OUT17/28452

**URBN SURF - Open Water Surf Sports Lagoon Facility (7942)
Comment on the Environmental Impact Statement**

DPI provides the following comments for consideration in assessment of the proposal.

Figure 12: Proposed circumstantial discharge route

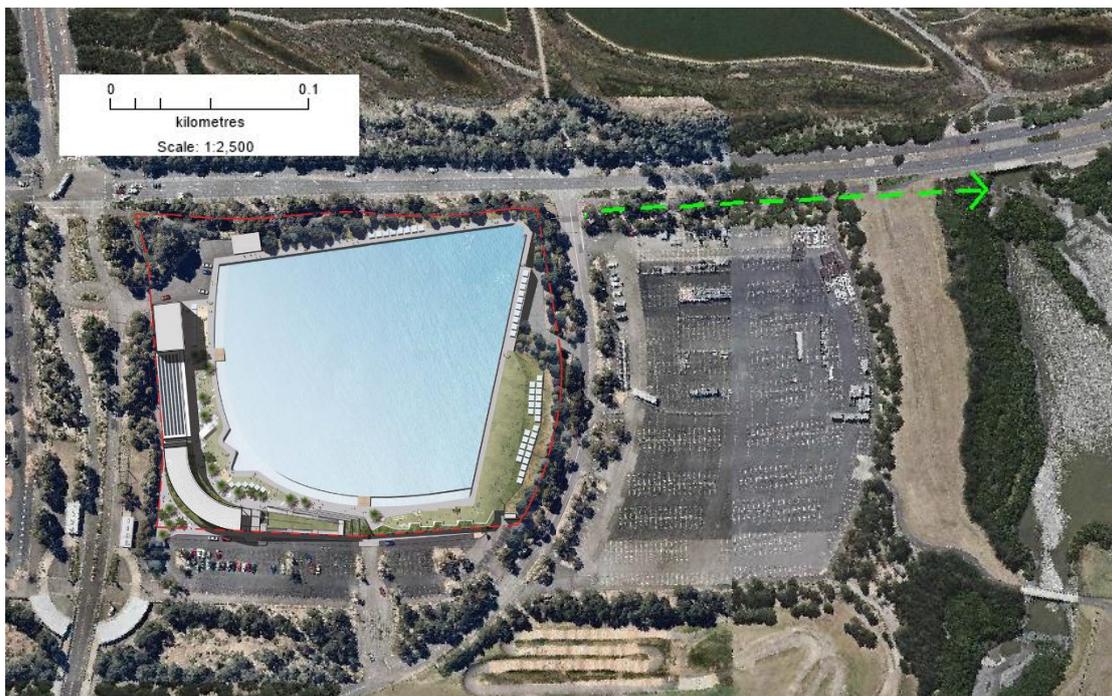
- The Water Treatment Monitoring Plan (Appendix 6 of Appendix 6) indicates that if Salmonella and Enterococci exceeds > 1000 counts the recommended action is to drain the surf pond (page 7 of 7). The Plan should clarify where the water is to be drained to and whether this is considered to be an emergency as:
 - Appendix 6 states “wastewater from the lagoon treatment process will be discharged to sewer” but it also states “emergency discharge of lagoon water will be via an existing drainage system discharging to the Nuwi wetland” (table 3, page 11)

- Appendix 10 states “no wastewater discharge to the environment”, “all lagoon wastewater will be discharged via the sewer” (point 1) and “lagoon water discharge via the existing drainage system to the Nuwi wetland” (point 2, page 64) and the emergency lagoon discharge point will be via an existing stormwater outlet to Nuwi wetland (page 64).
